Our Ref: AL/18/20/PL
Your Ref:

Town & Country Planning Act 1990 (as amended)
Town and Country Planning (Development Management Procedure) (England) Order 2015
Application for Planning Permission

Development Installation of modular ramp for access to front door
Location Flat 1 Sandcroft Westergate Street Westergate

Plan Produced for: Amber Living
Date Produced: 19 Feb 2020
Plan Reference Number: TQRQM20050111339477
Scale: 1:500 @ A4

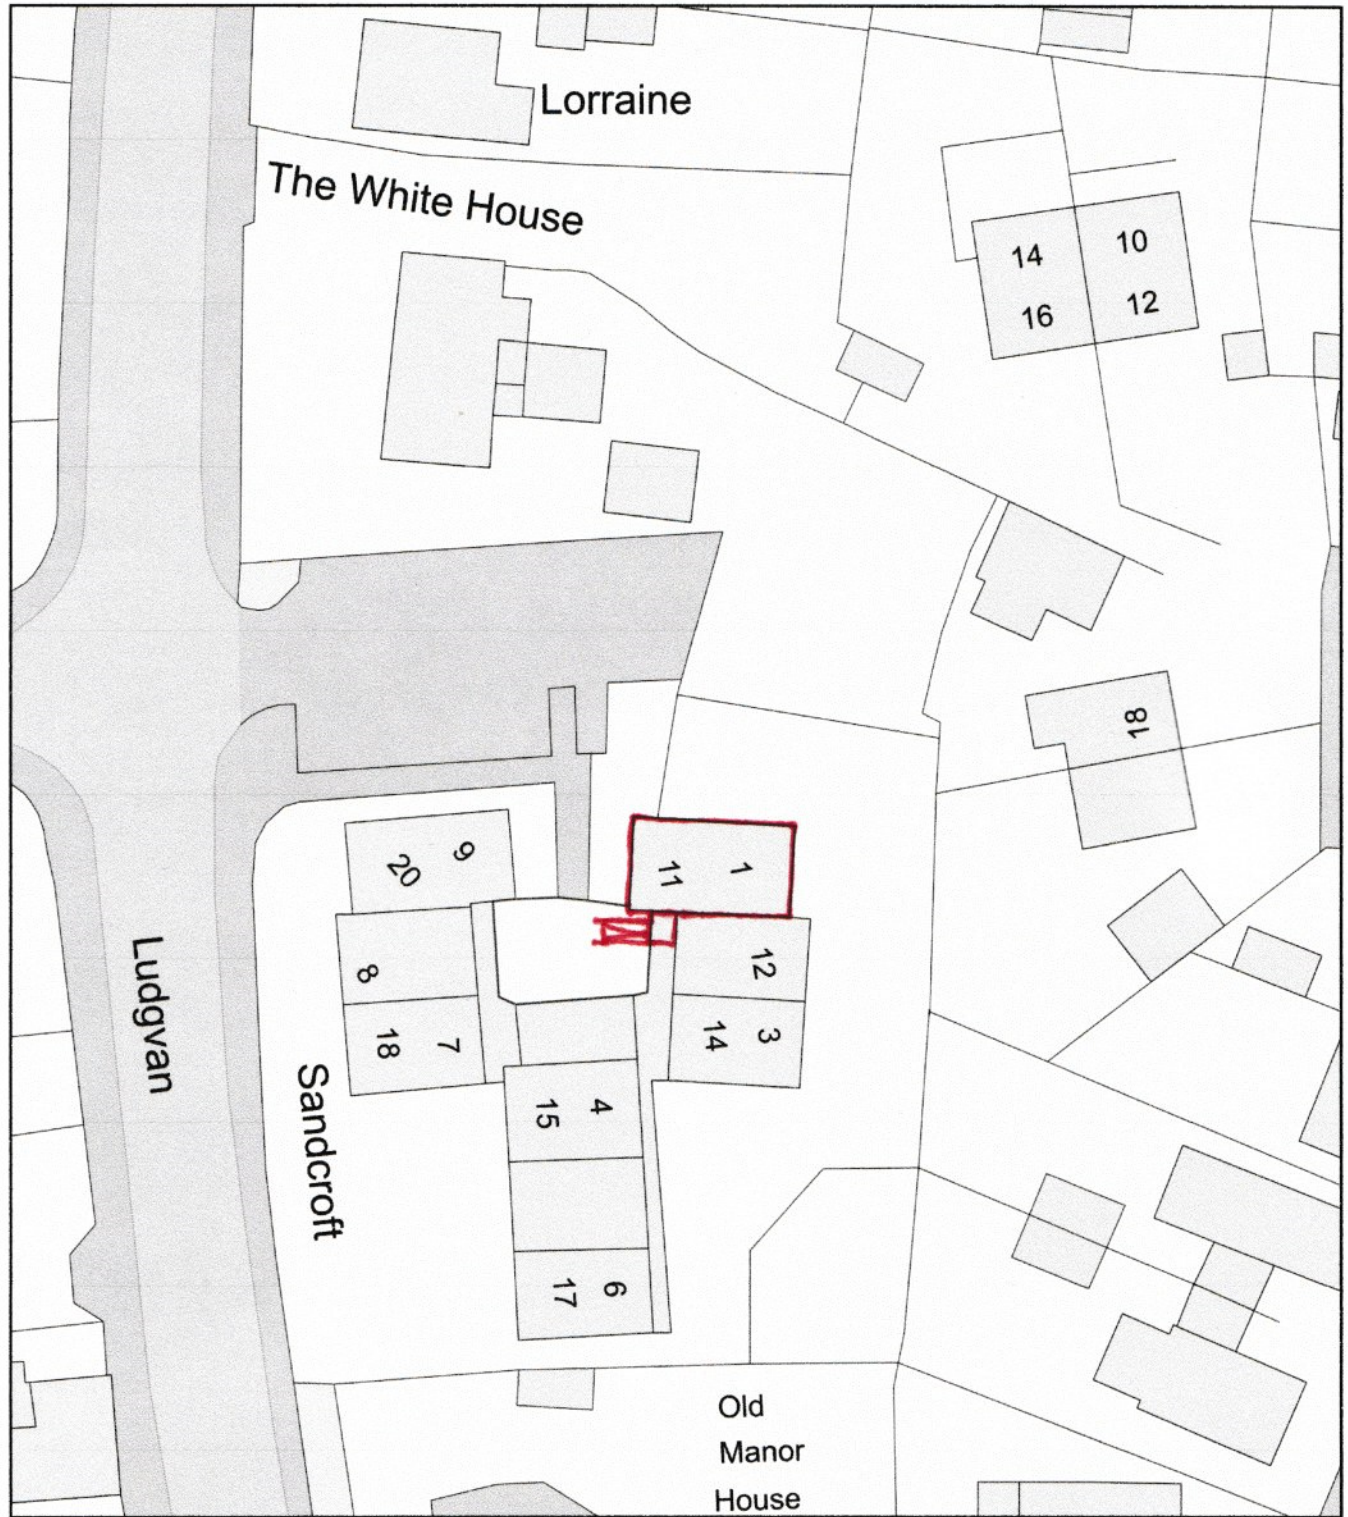
Block Plan Amend

Please show the position of the proposed works.

On the location and block plans, only red edge the application site and blue edge any adjoining land in the ownership/control of the applicant.
